July 7, 2005

RE: Application for Single Family House, Farragut Street, ID # 2005-0139

Upon review of the site plan, the City's Planning Division has the following comments:

SKETCH PLAN
 84 FARRAGUT STREET PORTLAND, MAINE

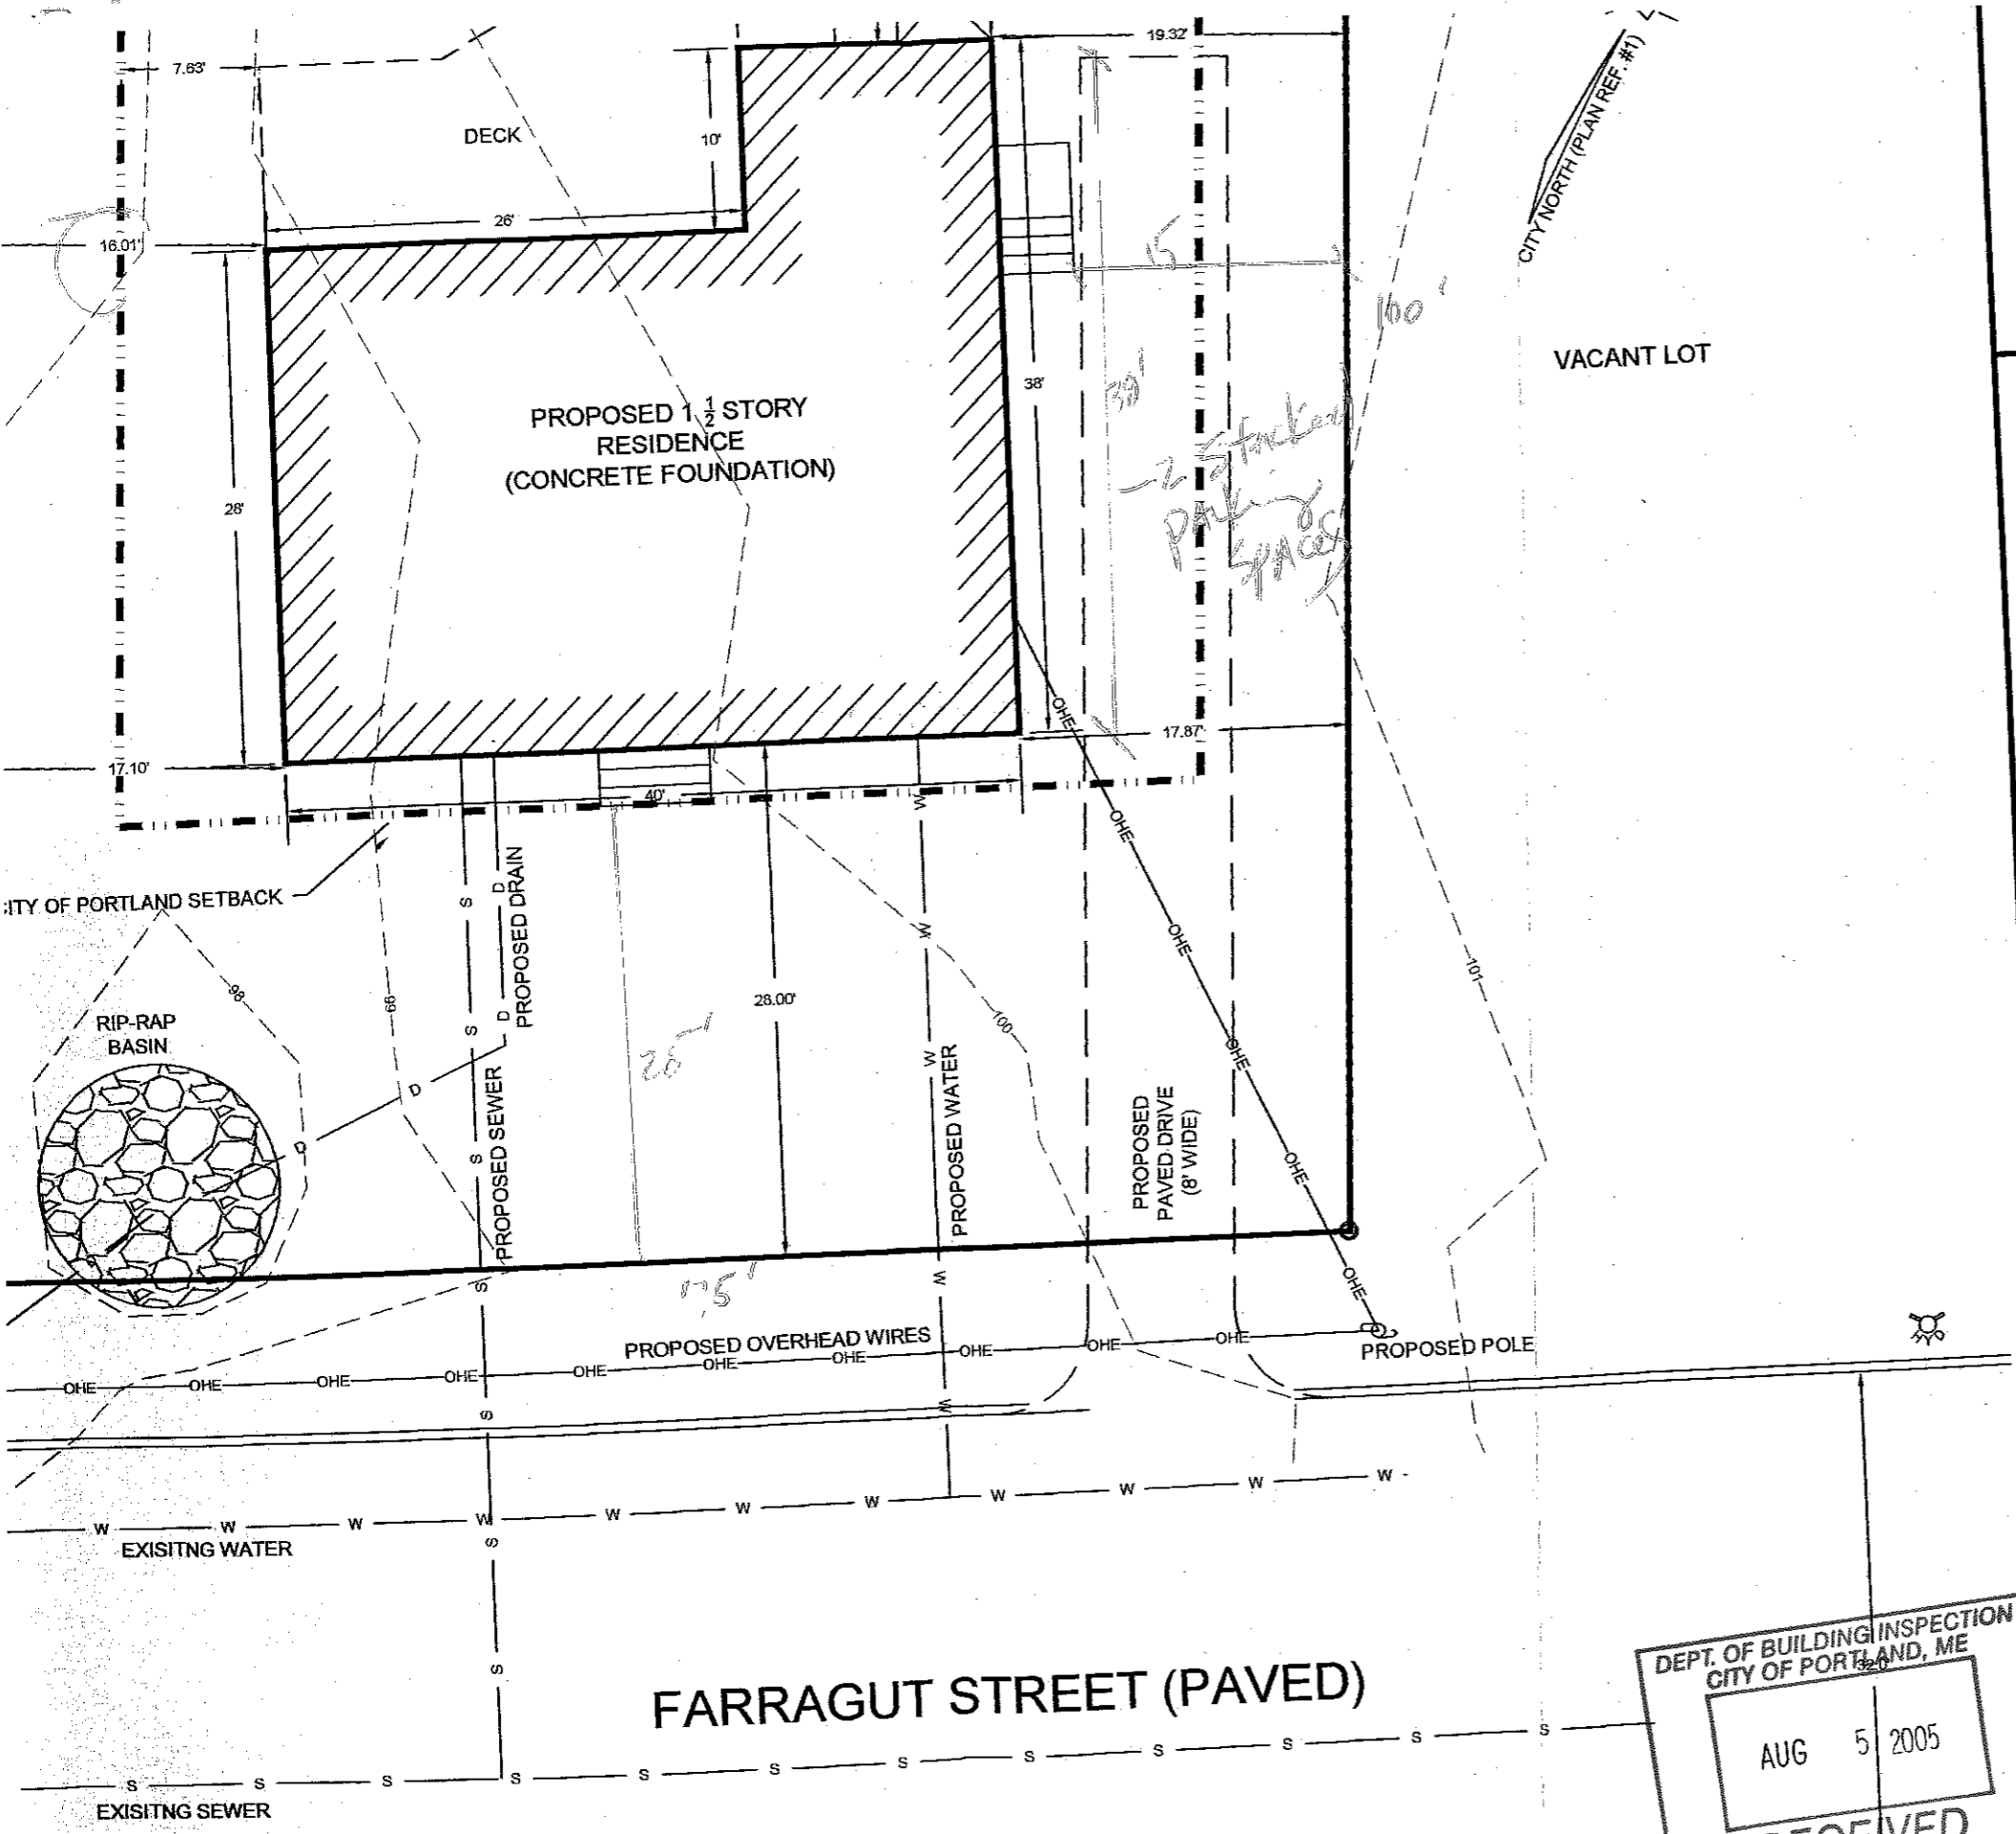
1. Please provide proposed grading/topography on the lot. This should match the previously approved grading as shown on the Farragut Street Extension plans approved on April 16, 2003. Add to plan.
2. Please note the Finish floor elevation. This should be tied into the same elevation data as your proposed topography.
3. Add the distances of the lot lines to the site plan.
4. Two street trees are required for single-family development, along your street frontage. Add to plan.
5. A backflow preventer is highly recommended on the 4" storm drain lead. Please add a note to the plan.
